From: David Gould
Sent: 09 August 2022 11:52
To: Planning Mailbox
Cc: Helen Wallis
Subject: RE: Planning Application 22/0313/HH

Planning Application reference number 22/0313/HH

15 Main Street Kilby

Thank you for consulting me with regard to this planning application, which is for the conversion of old barn to form habitable annex-style living accommodation, subsidiary to the main dwelling.

Drawing Title: Proposed Plans and Elevations

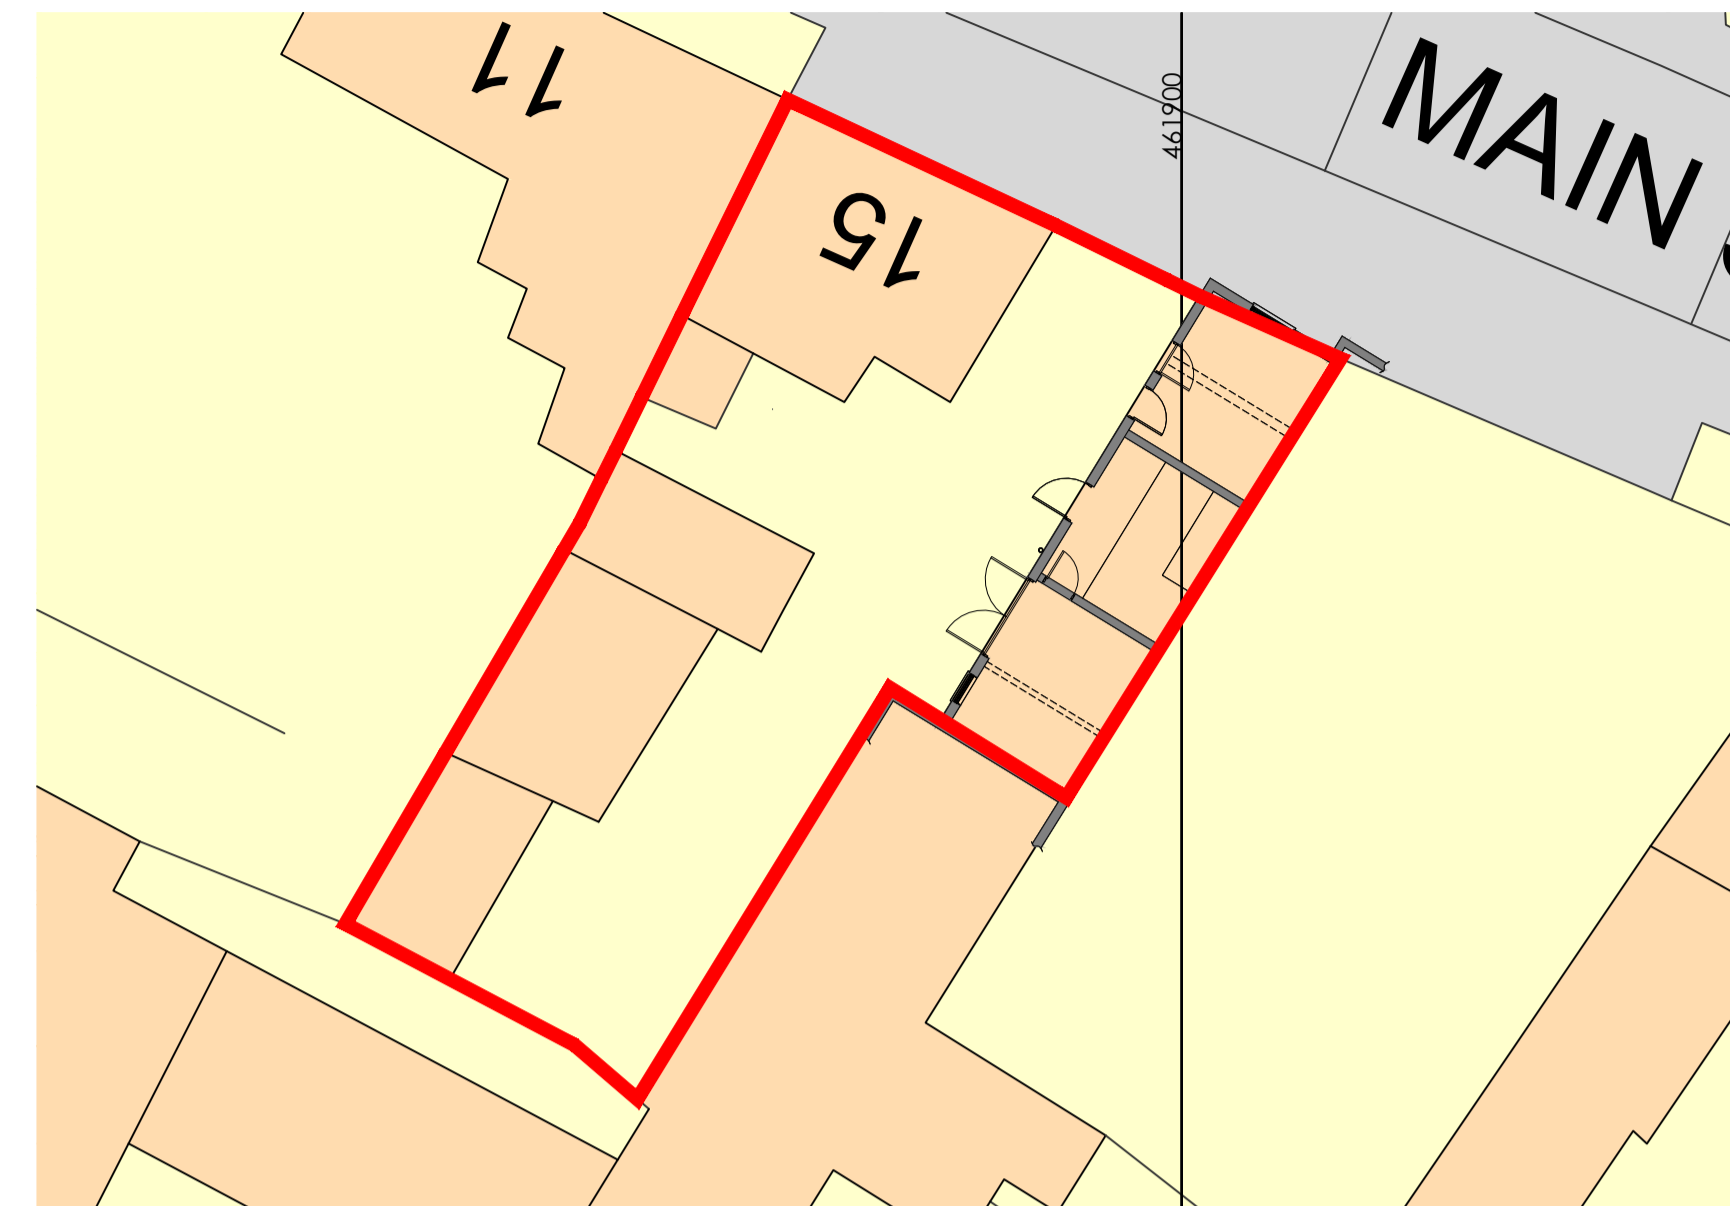
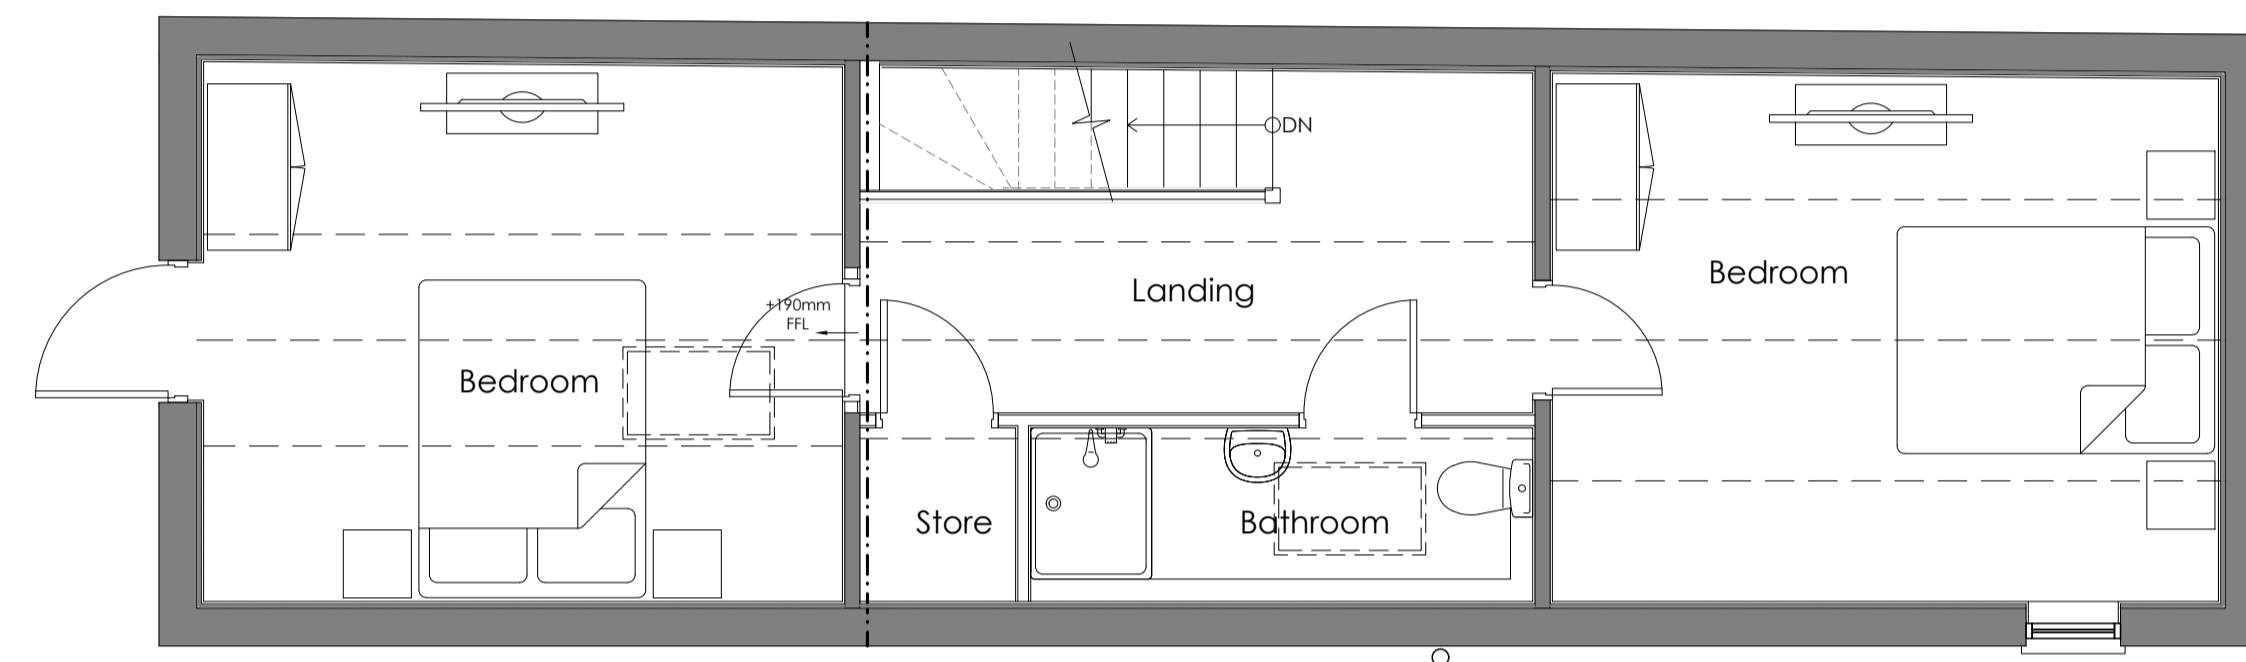
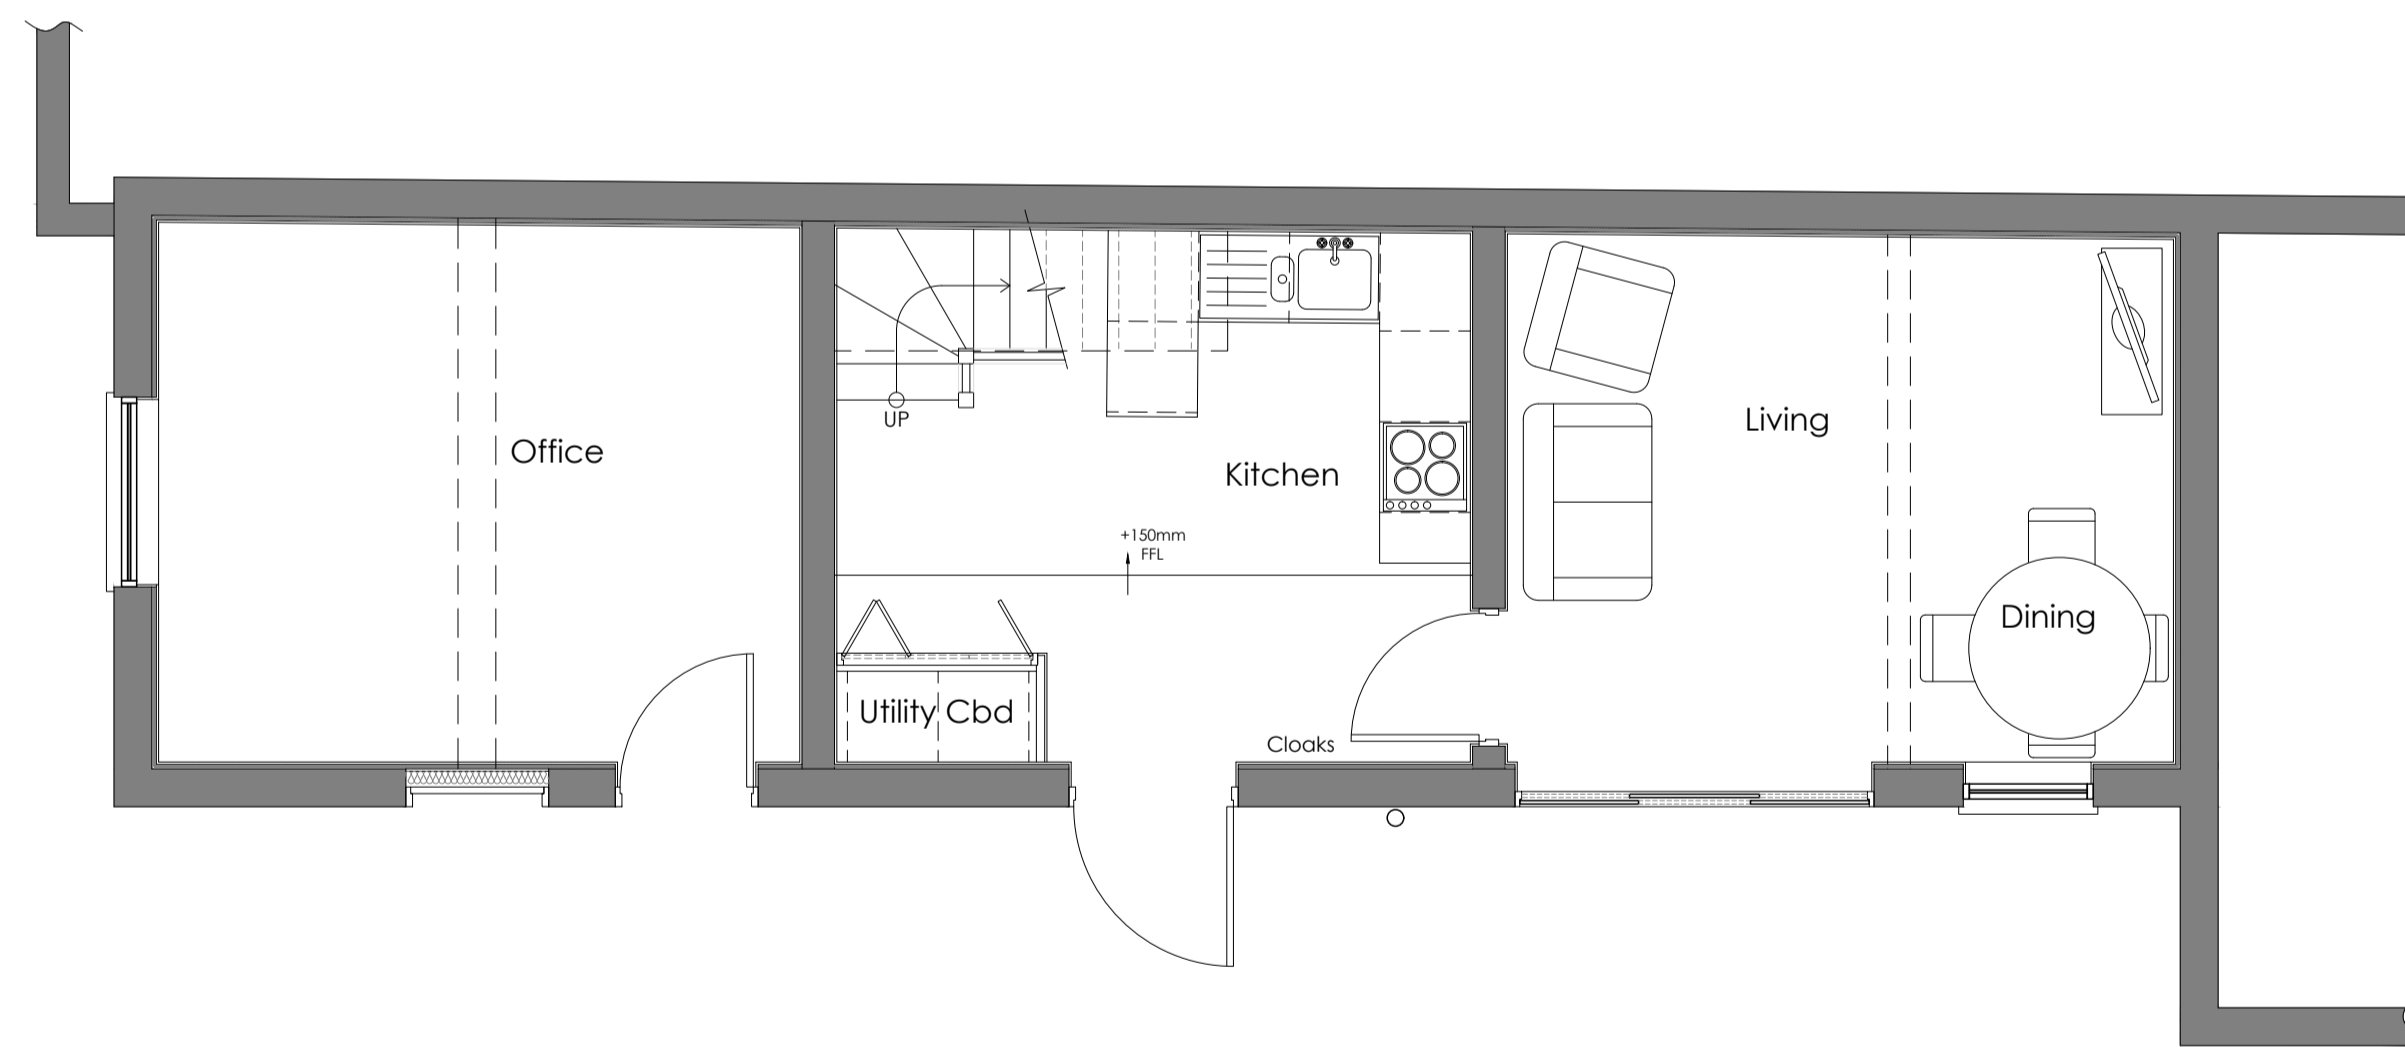
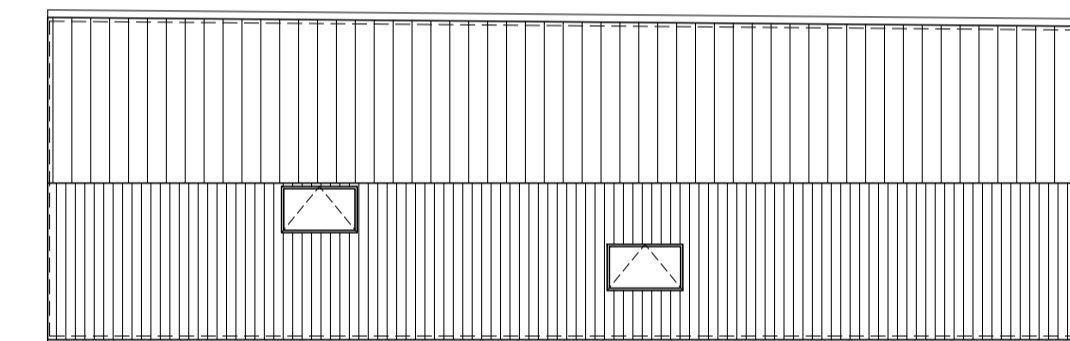
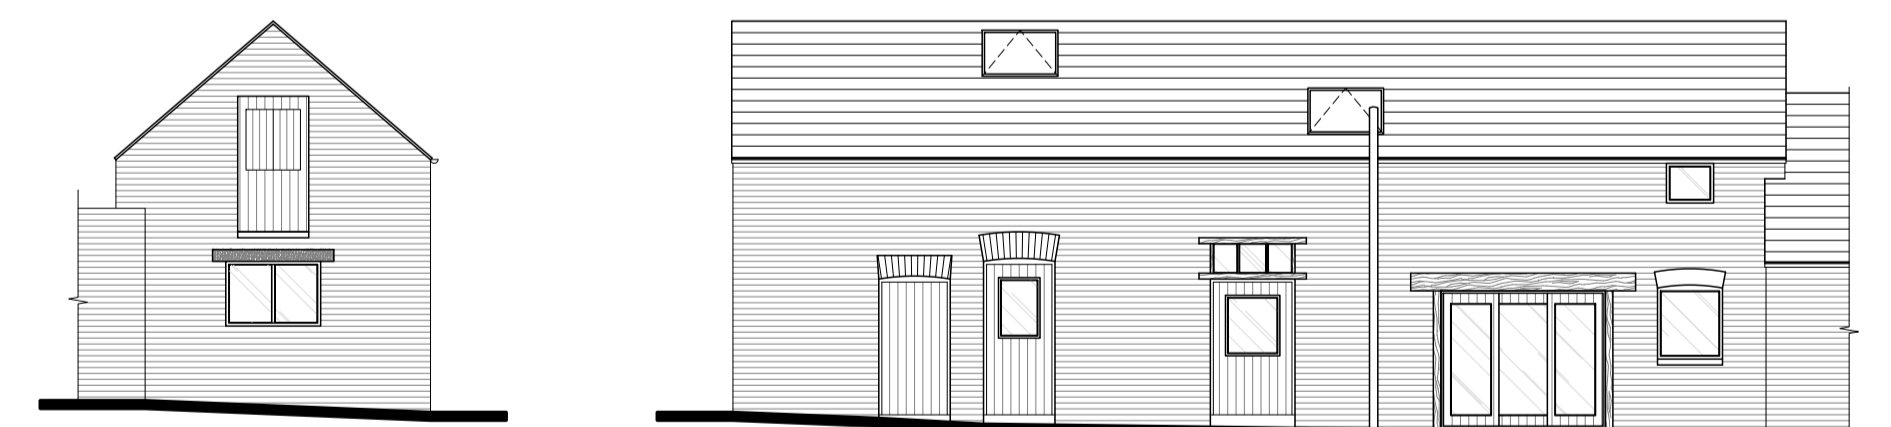
The submitted plans and elevations show a kitchen and bathroom which will produce foul water, however there are no details of how this is to be disposed of. A detailed layout could be submitted at a later stage by way of a suitably worded condition. However I would prefer the applicant to state prior to determination whether mains sewerage is to be used or not.

There are also no details of how surface water is to be disposed of. Some areas of Kilby village have been subjected to historical flooding. I note that the proposed development site is not within Flood Zone 2 or 3, and that no new areas of roof are proposed. If new rainwater goods are to be installed as part of the scheme, I would encourage the use of appropriate SUDs features to minimise the volume of piped surface water that leaves the site. It would be useful if the applicant could clarify intentions relating to surface water drainage.

I note that there will be no alterations to the arrangements for disposing of surface water. I also understand that foul water is to be disposed of using mains sewer. I am happy to remove my previous objection.
